**KIRKLEES METROPOLITAN COUNCIL
INVESTMENT & REGENERATION SERVICE**

DELEGATED DECISION TO DETERMINE PLANNING APPLICATIONS

Reference No:	2021/62/94201/E
Site Address:	53, Whitley Road, Thornhill, Dewsbury, WF12 0LP
Description:	Erection of conservatory extension with alterations to existing elevation and extension of external patio area including reconstruction of existing retaining wall and incorporation of external store
Recommending Officer:	Elenya Jackson

DECISION – Conditional Full Permission

BOUNDARY

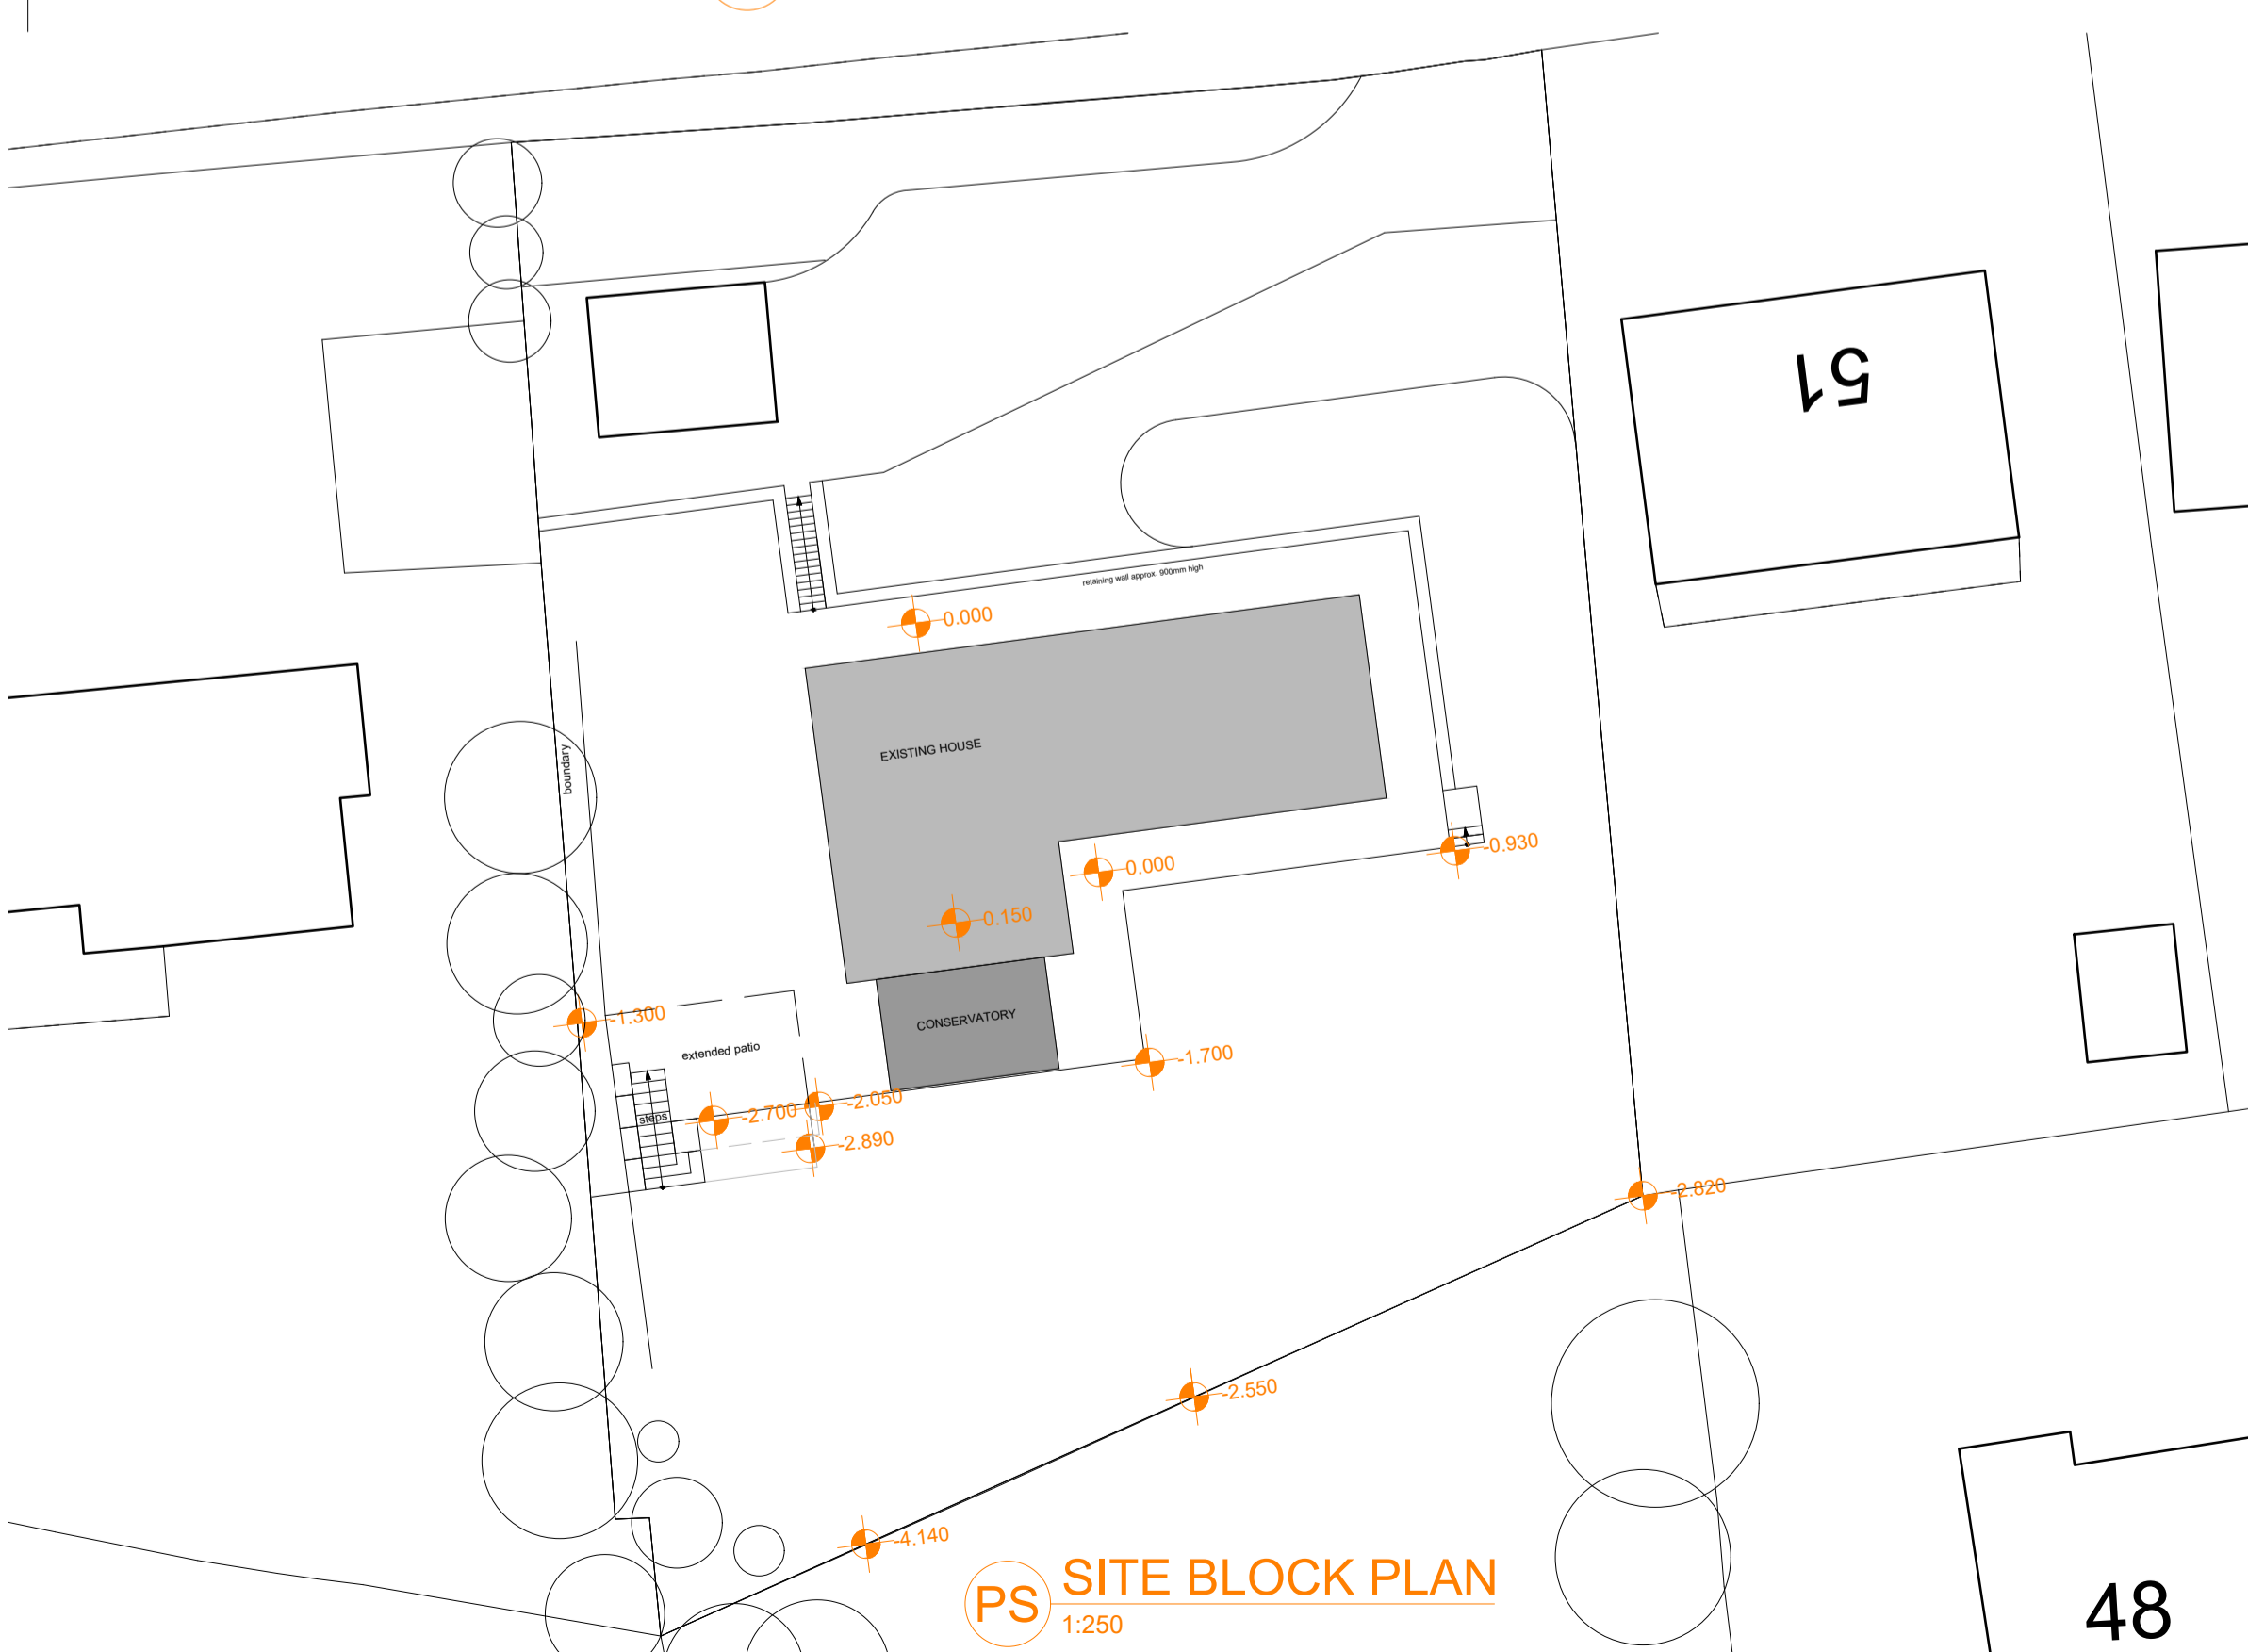
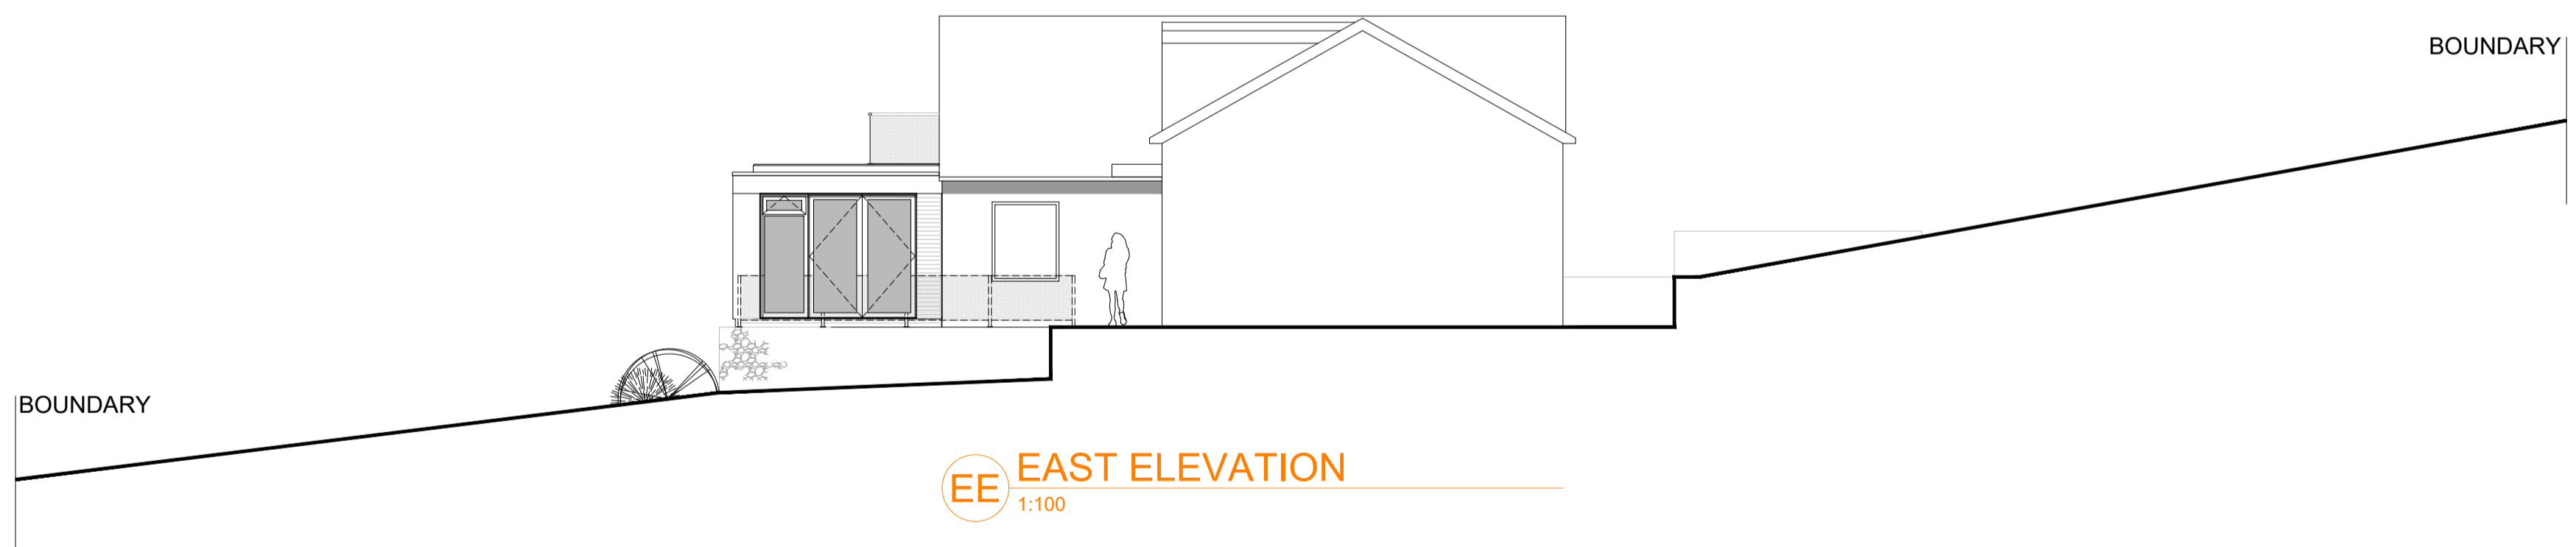
Overlooking: The proposal would be situated 10m away from the shared boundary between the two dwellings and features side facing fenestration. It is considered that a condition requiring a screen to the western elevation of the balcony would sufficiently mitigate any overlooking relationship and this has been agreed with the agent.

4. Notwithstanding the details submitted, prior to the construction of the first floor balcony hereby approved, details of a 1.8 meter privacy screen to be erected along the western elevation of the balcony shall be submitted to and agreed in writing by the Local Planning Authority. Details shall include materials and extent of screening. The privacy screen(s) shall be installed and retained thereafter for the lifetime of the development
